A66 NTP: Cumbria County Council - PRINCIPAL AREAS OF DISAGREEMENT SUMMARY STATEMENT

Drawing Title: De-trunking Plan Regulation 5(2)(o) Sheet 1 of 1

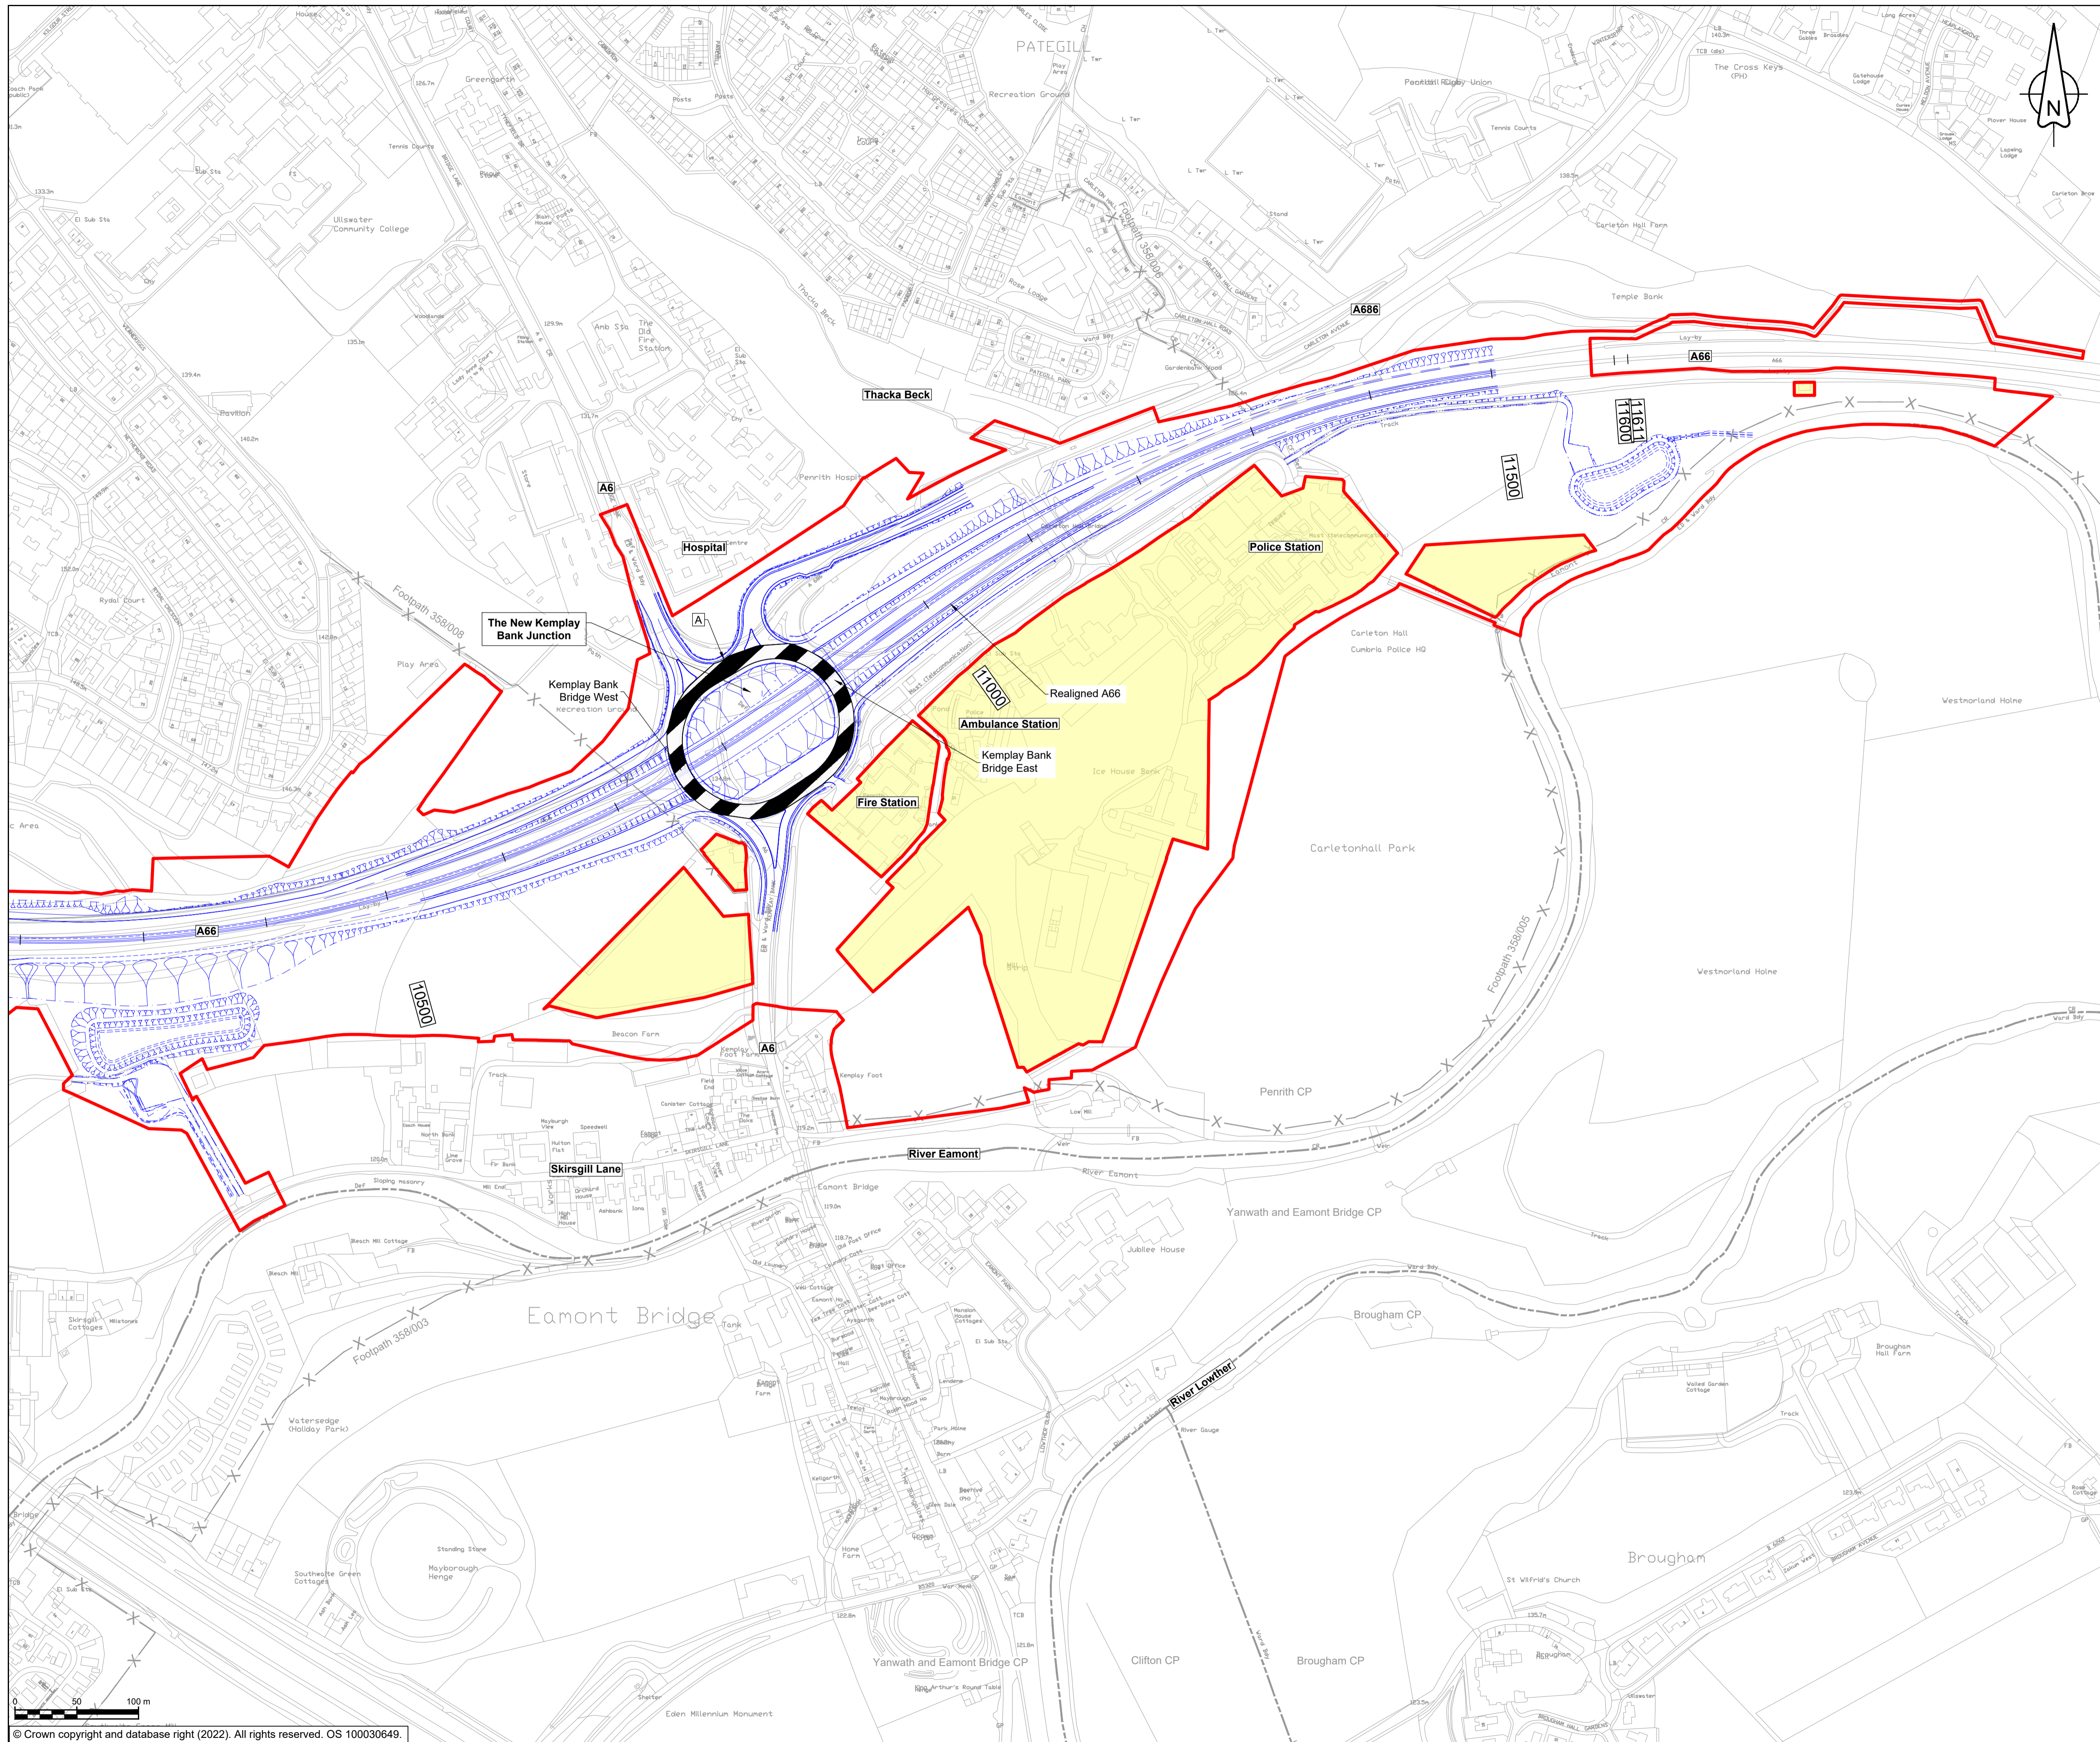
12 Penrith Area	Detrunking of roundabout into local network and liability for bridge structures. Unclear what the detrunking proposals for the KB roundabout will mean for the Council. The Council is not willing to accept maintenance liability for the roundabout, which includes new overbridges, lighting, traffic signals, etc	NH need to explain their proposals for detrunking of the roundabout and what arrangements will be put in place for future operation and maintenance. See also comments on 'Detrunking' below	There is a need for the Council to be adequately resourced to examine the DCO submission and engage in the DCO application process to understand the proposals for detrunking at Kemplay Bank
13 Penrith Area	The Council is not satisfied that impacts on the local road network, on Ullswater Road, Clifford Road and Eamont Bridge have been adequately assessed.	See Traffic Flows and Modelling below See also comments regarding M6 diversions under Diversions below	There is a need for the Council to be adequately resourced to examine the DCO submission and engage in the DCO application process to understand the impacts of the proposals at Ullswater Road, Clifford Road and Eamont Bridge and review the modelling approach and traffic forecasts.
